Your ref:
Our ref: 21/02146/F
Please ask for: Miss Sandra Homcenko
Direct dial: 01553 616824
Direct fax: 01553 616652
E-mail: borough.planning@west-norfolk.gov.uk

Details: **The proposed works are to create a safer, more traffic friendly incoming vehicular entrance to our property.**

Proposed New Driveway Entrance

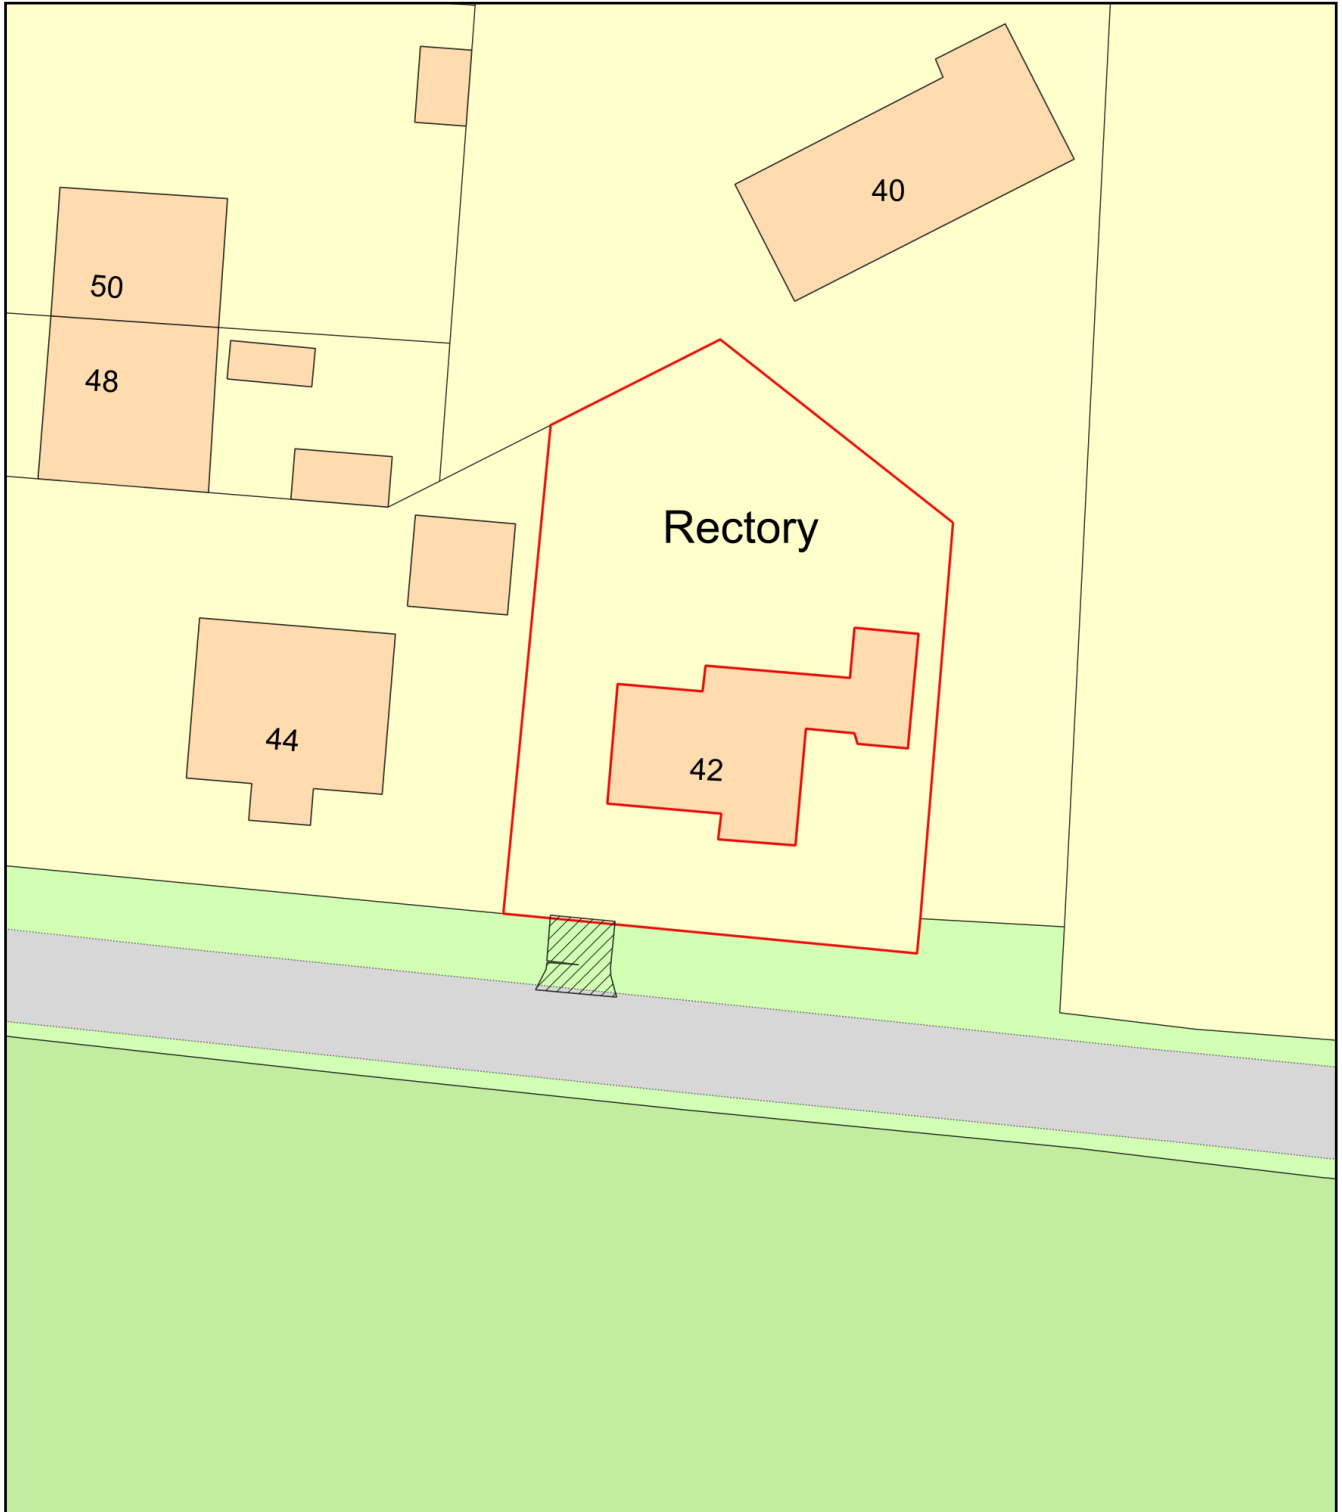
1. Please include a new access as a part of red line
2. Please confirm in writing if you would agree to change the description of proposal to: "New Access"
